Response to Planning Application

From: Arun District Council Leisure & Greenspace

Application ref: A/168/21/PL

Description: Erection of 76 No. dwellings, means of access, public open space, play areas, associated infrastructure & landscaping. This application is a Departure from the Development plan, is in CIL Zone 5 and is CIL Liable as new dwellings & affects a Public Right of Way.

scheme: Land South of A259,
Angmering
client: Redrow Homes Ltd.
drawing: LAP Proposals
date: June 2021
scale: 1:100@A1
dwg no: RED23031-21 DR
drawn: JH checked: DKM

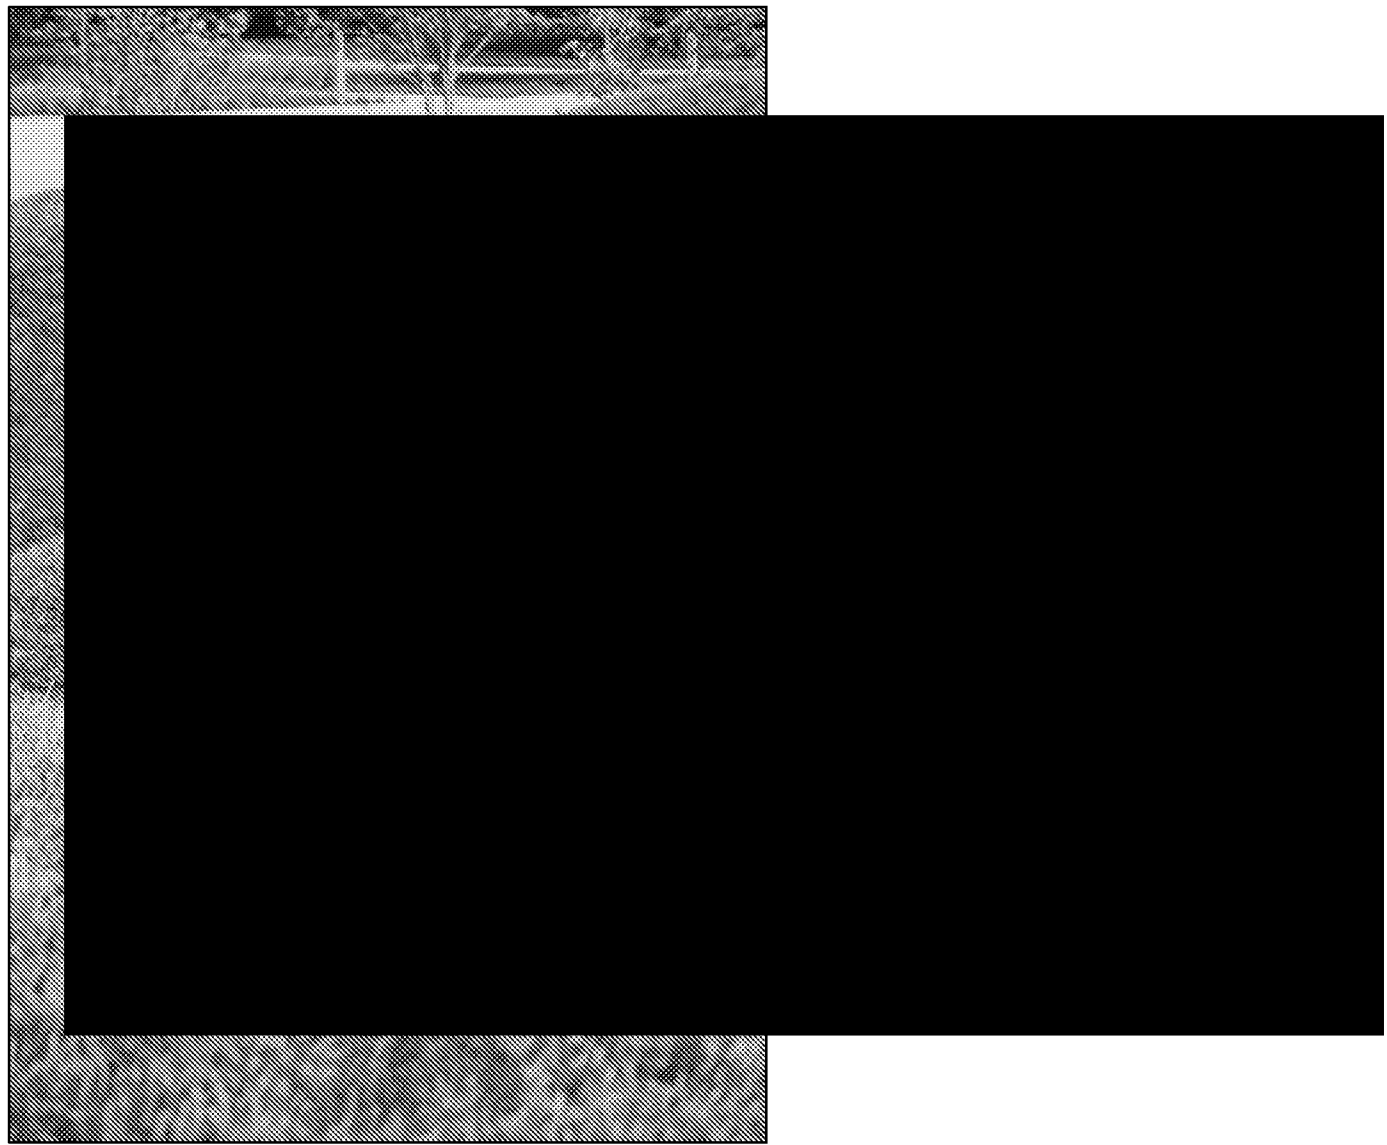
This development will trigger the requirement for play in the form of onsite LAPs and LEAP provision, which needs to be suitable for location in material choice and play experience offer. Both LAP and LEAP have been indicated and appear to be well located within the development which is good to see. Further detail re Play would need to be submitted for approval: LEAP proposals dwg RED 23031-20 has propose a scheme which does not entirely meet requirements re play experiences or inclusion. Accessibility would need to also be confirmed along with pathways which appear to be grassed at present but which would need to allow for all weather access by pedestrian and wheeled users. The fencing type is indicated as timber post and rail with matching gates? These need to be self-closing and allow for maintenance operations. Confirmation of maintenance re the play areas would need to be confirmed as the LPA may not be supportive of timber fencing if the areas were to be considered for LPA maintenance adoption.

Further detail required re LAP proposals dwg RED 23031-21 DR which requires further detail also re fencing and access.
